## STRUCTURAL PLAN CHECK REPLY FOR

2405 74<sup>TH</sup> AVE SE,  
MERCER ISLAND WA  
PERMIT #2112-257

### **Structural, Plan check reply**

Project: IMANI RESIDENCE

C1 "L" SHAPED RETAINING WALL
3/4"=1'-0"

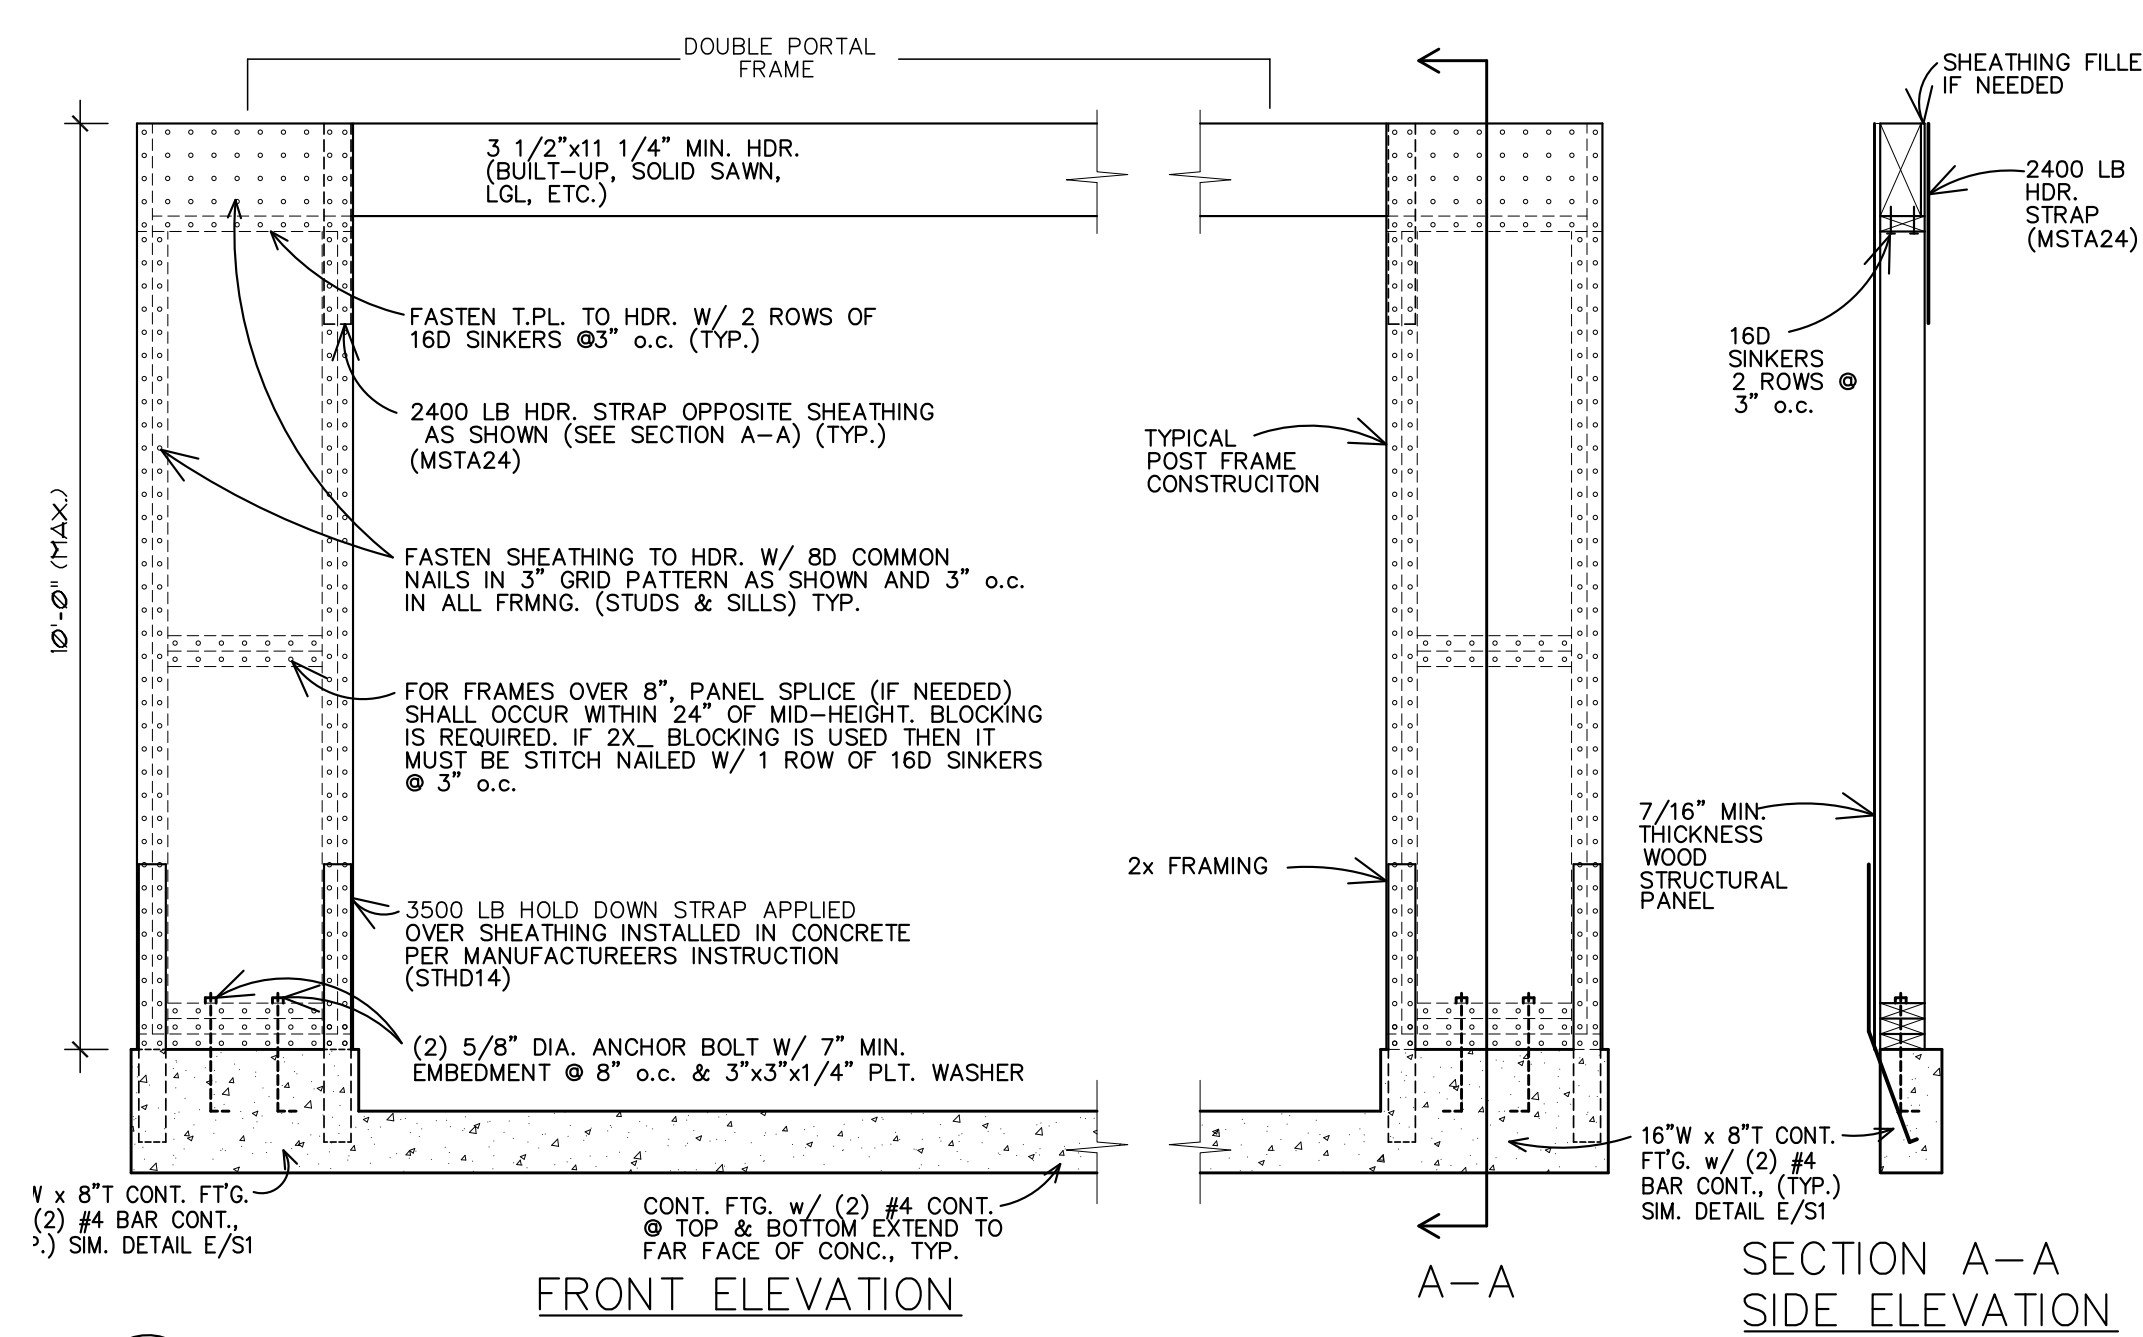
**Item #3:** Retaining walls on foundation per C/S1 detail and schedule.

X1 UPSET BEAM @ FLR.
1"=1'-0"

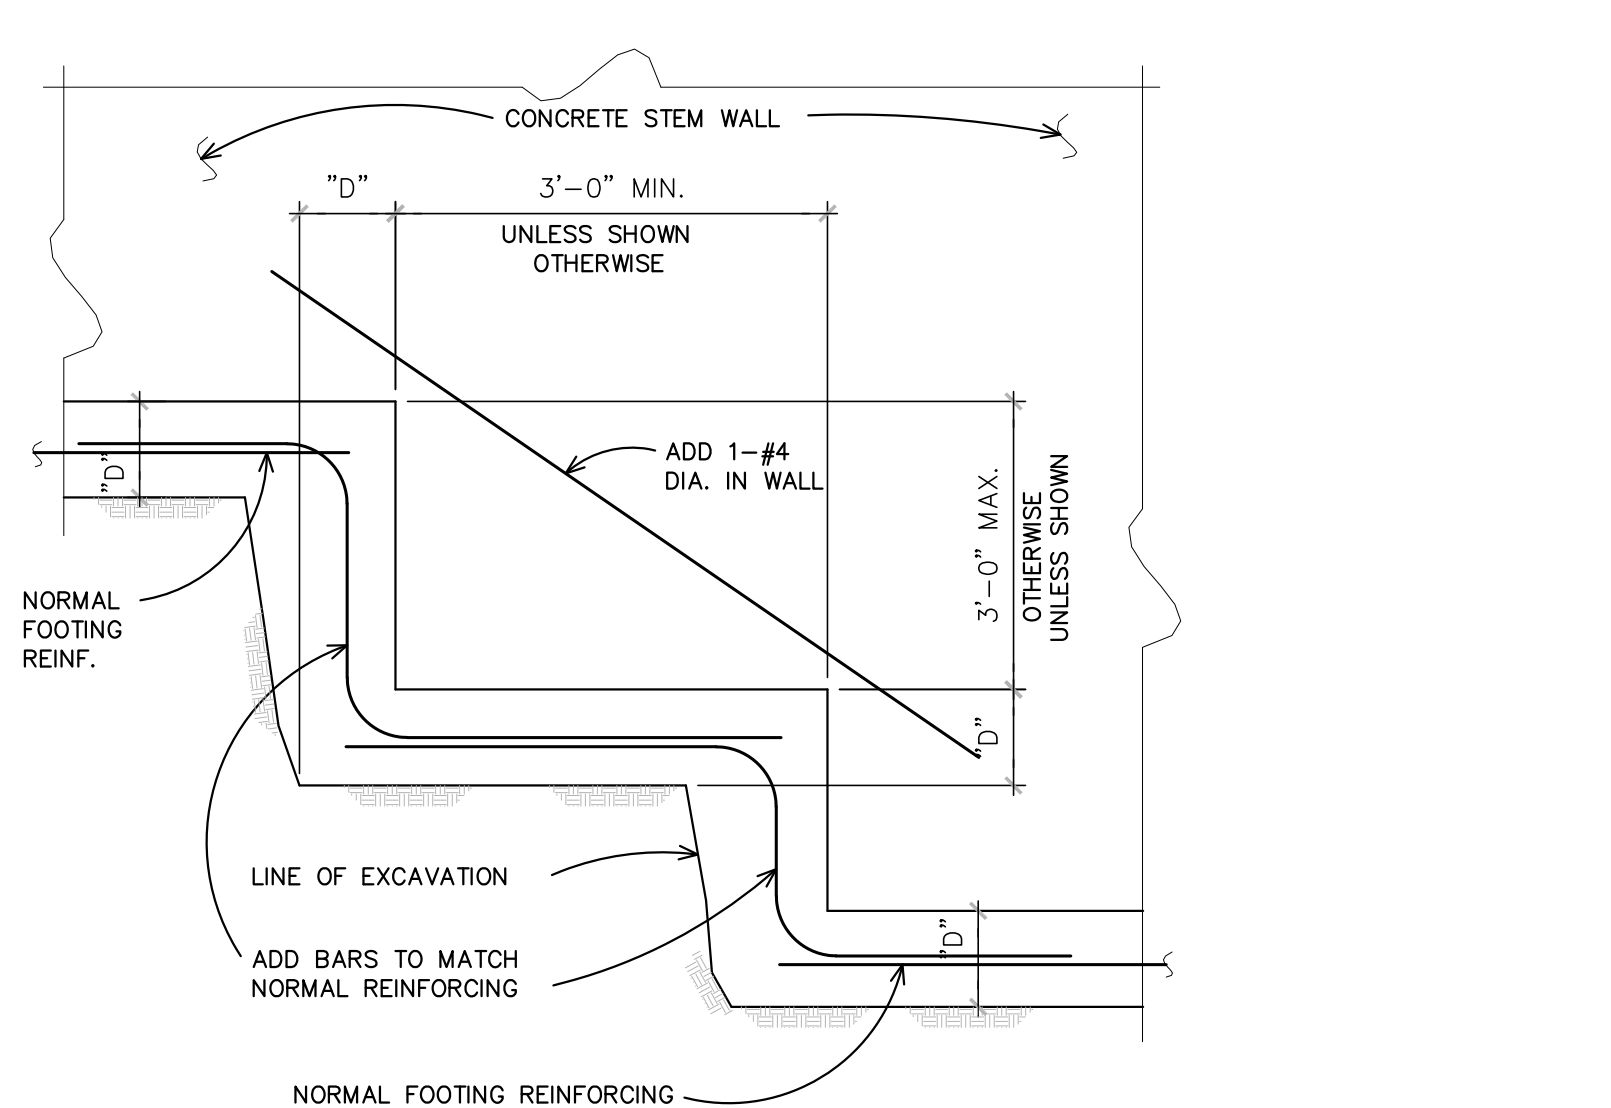
**Item #1:** Due to loading, beam needs to be 14" deep which is greater than 11-7/8" floor joists and will be upset into the wall above.
